ASSESSMENT REPORT

Printing Warehouse and Distribution Facility Erskine Park Penrith MP 08_0016 MOD 2

Drawing title:
LOT 2 SITE PLAN

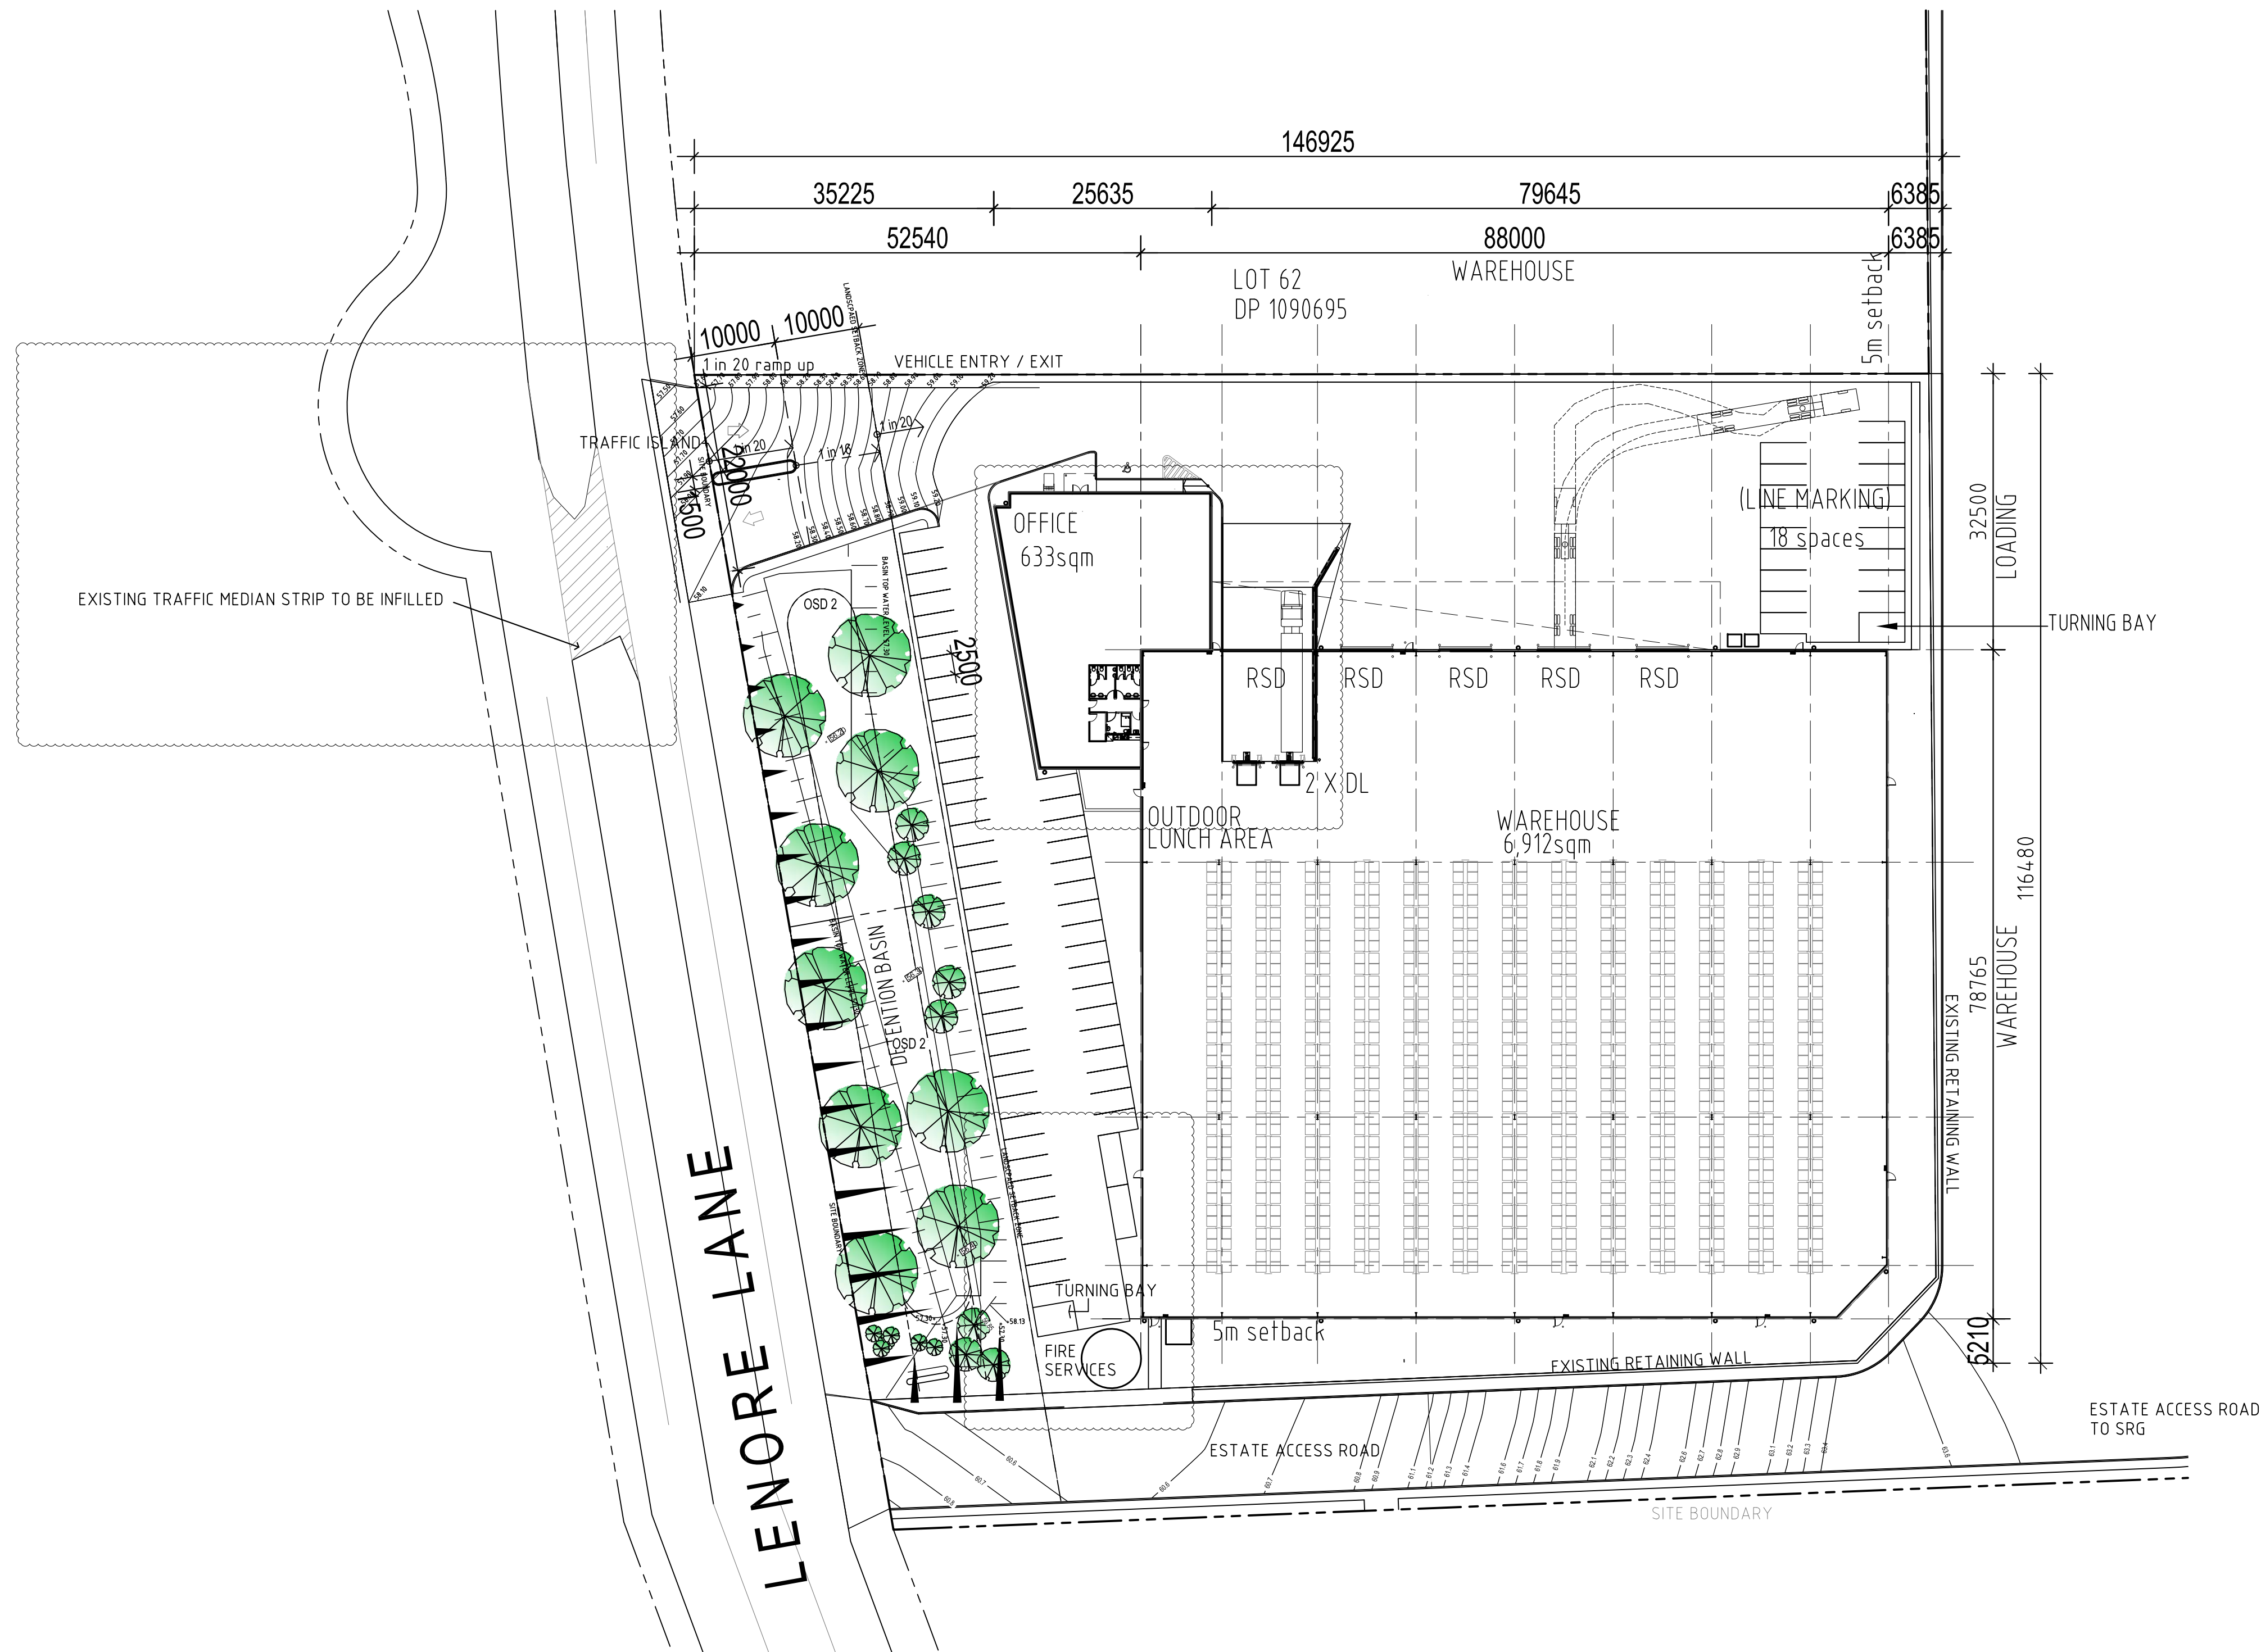
Roads and Maritime Services raised no objection to the proposal however requested that car and truck driveway movements be limited to left in/left out at the western boundary of the site by physically closing the existing gap in the median island along Lenore Drive. It also requested confirmation that the stormwater discharge into the RMS owned drainage system does not exceed the predevelopment discharge. It also suggested other conditions, consistent with existing conditions within the approval.

<i>Traffic</i>	- The Transport Impact Assessment submitted with the modification predicts the proposal would result in 20 additional vehicle movements per hour. - Although this represents an increase in traffic movements to and from the site, the assessment found there is adequate capacity in the surrounding road network to cater for the additional vehicle movements. - The Department accepts the findings of the traffic assessment and is satisfied the proposal and would not result in any adverse traffic impacts.	No additional conditions or amendments necessary.
<i>Access</i>	- The RMS requested vehicle be limited to left in/left out movements at the western boundary of the site by physically closing an existing gap in the median island along Lenore Drive. - In response to this issue, the Proponent agreed to close the median strip to prevent right hand turns to and from the site. - Subject to the closure of the median strip, the Department is satisfied the proposed modification would not result in any adverse access impacts.	The Department has recommended a new Condition 3C requiring closure of the median strip.

Drawing title:
BUILDING ELEVATIONS

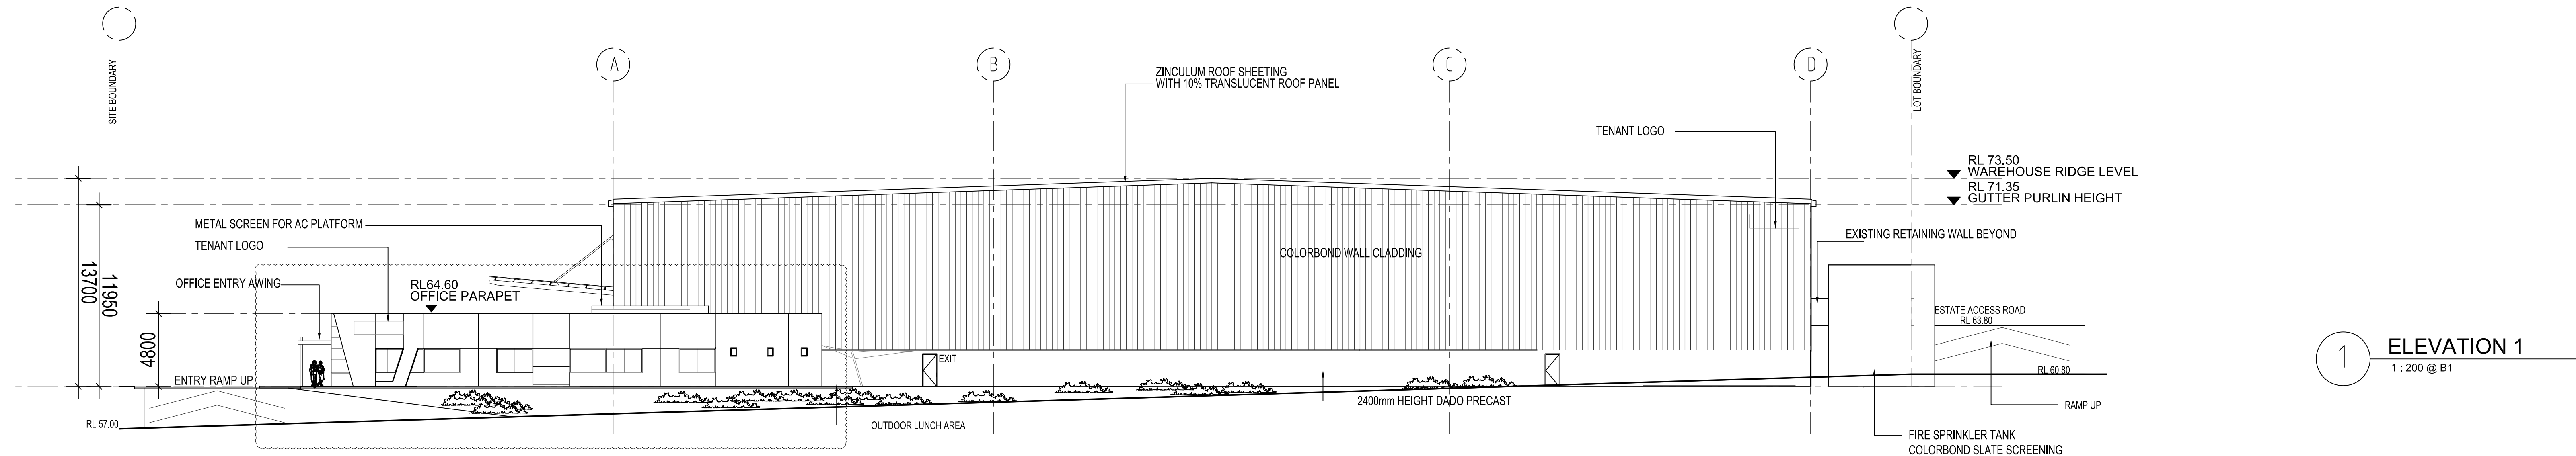
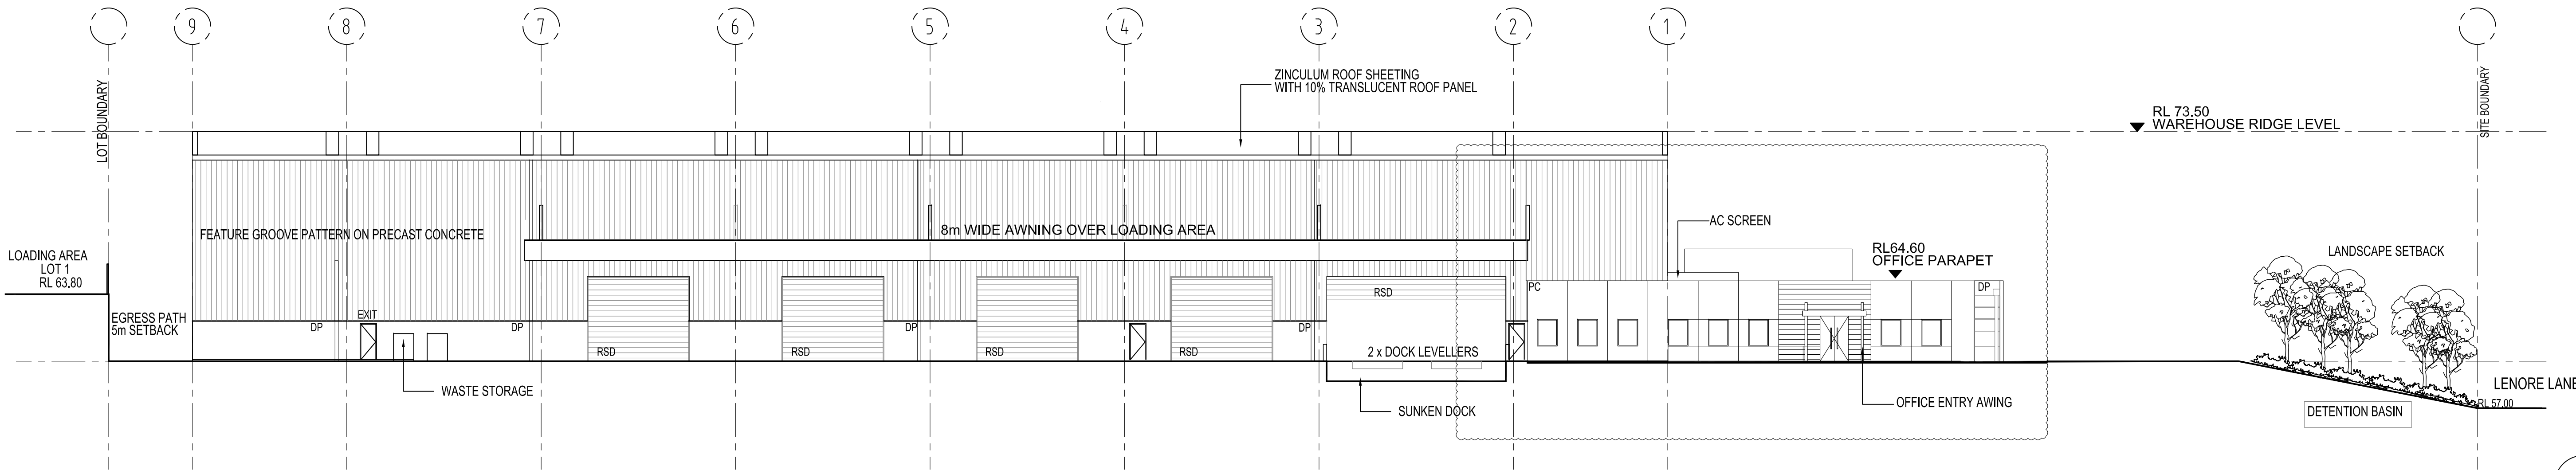
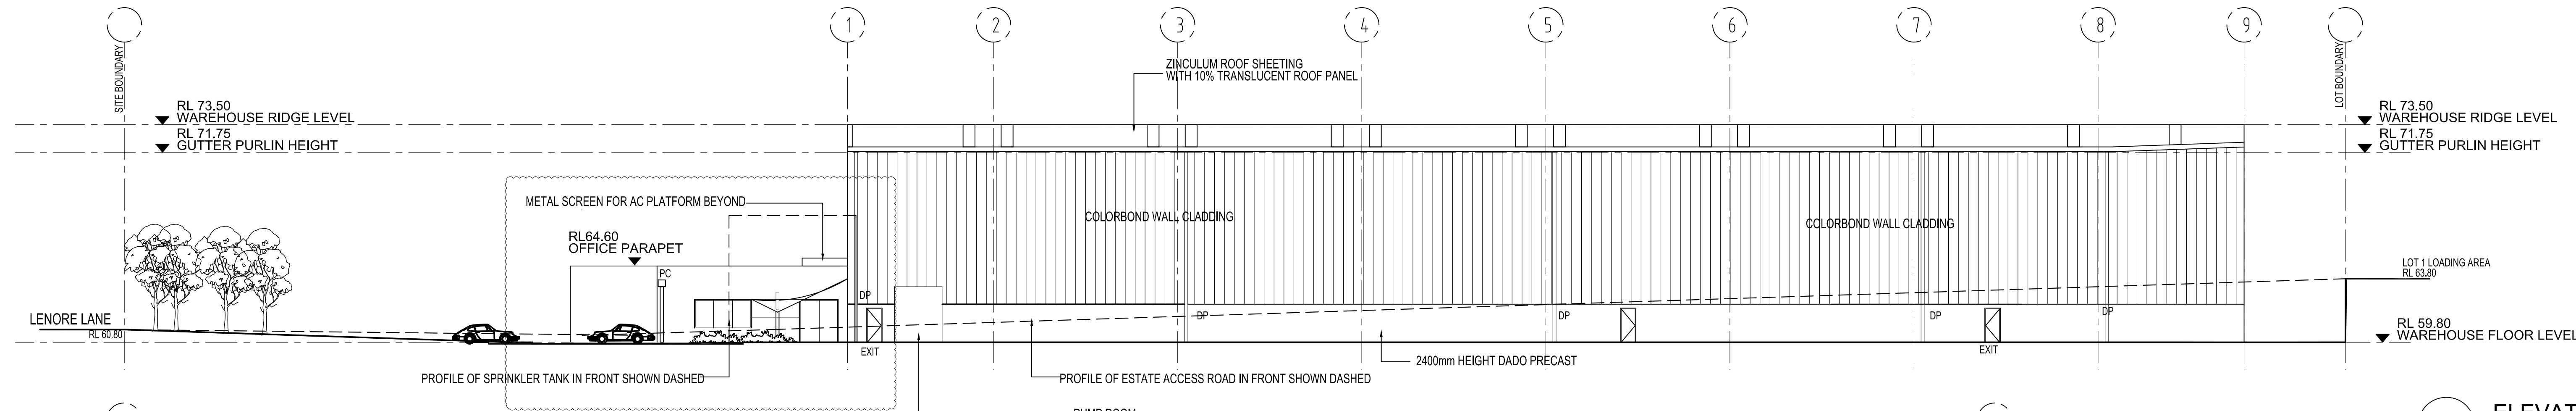
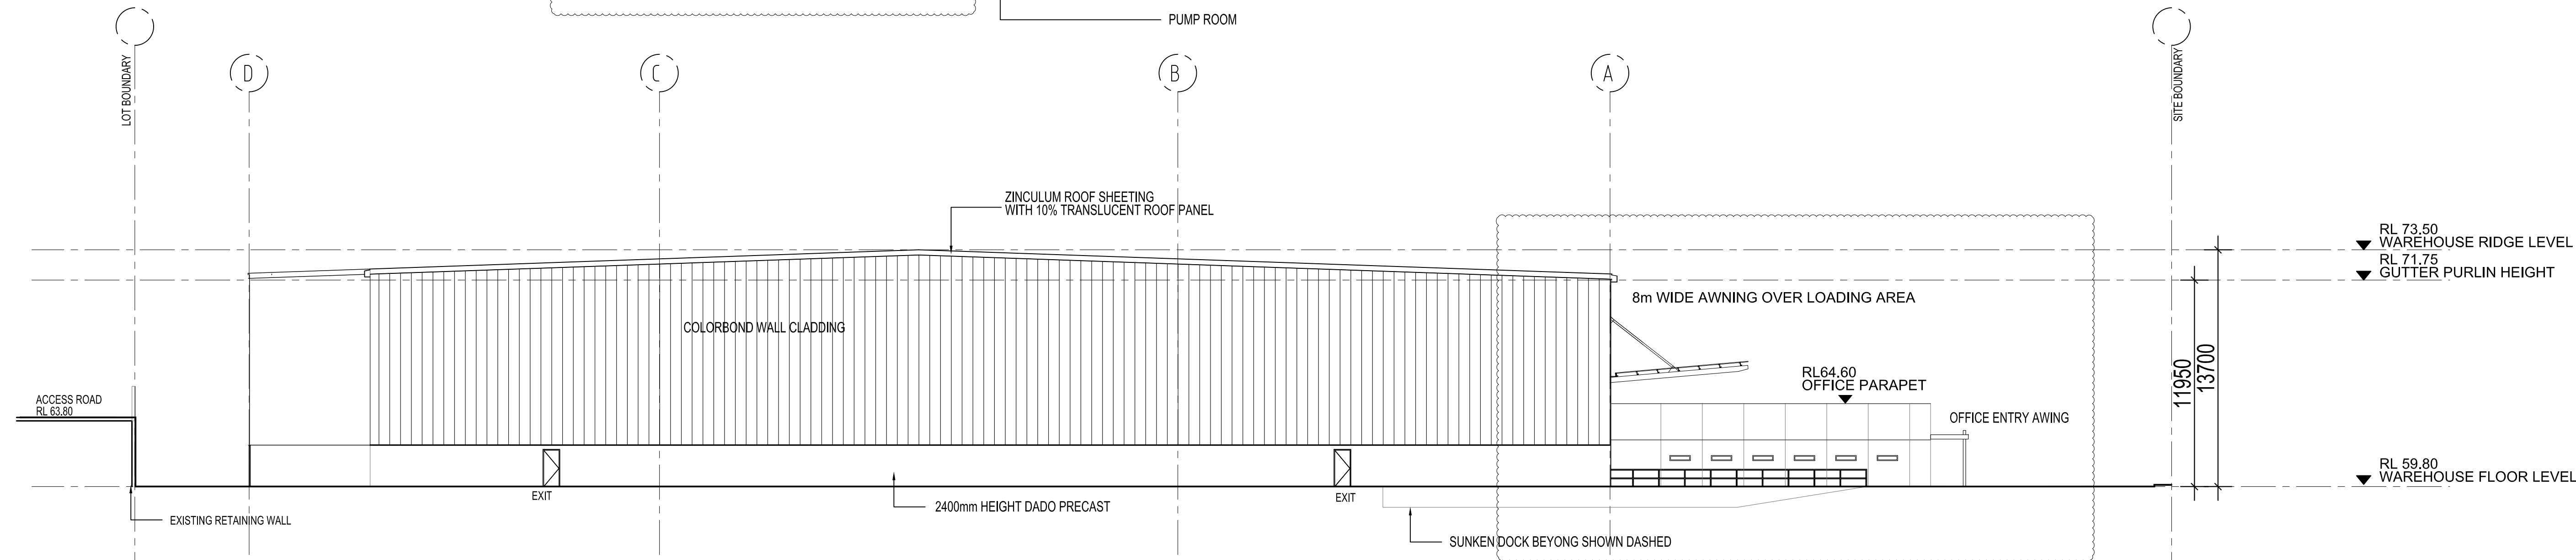
Penrith City Council raised no objection to the proposal however outlined measures to encourage Urban Design improvements on the site, including breaking up the large expanses of wall, with additional architectural treatments, building articulation, fenestration and a variety of external finishes at the southern end of the eastern elevation to improve the building form. Council asked that sprinkler tanks also be relocated away from publicly visible areas and instead are integrated into the building and the front fencing should be located behind the landscaped setback and be of an open style.
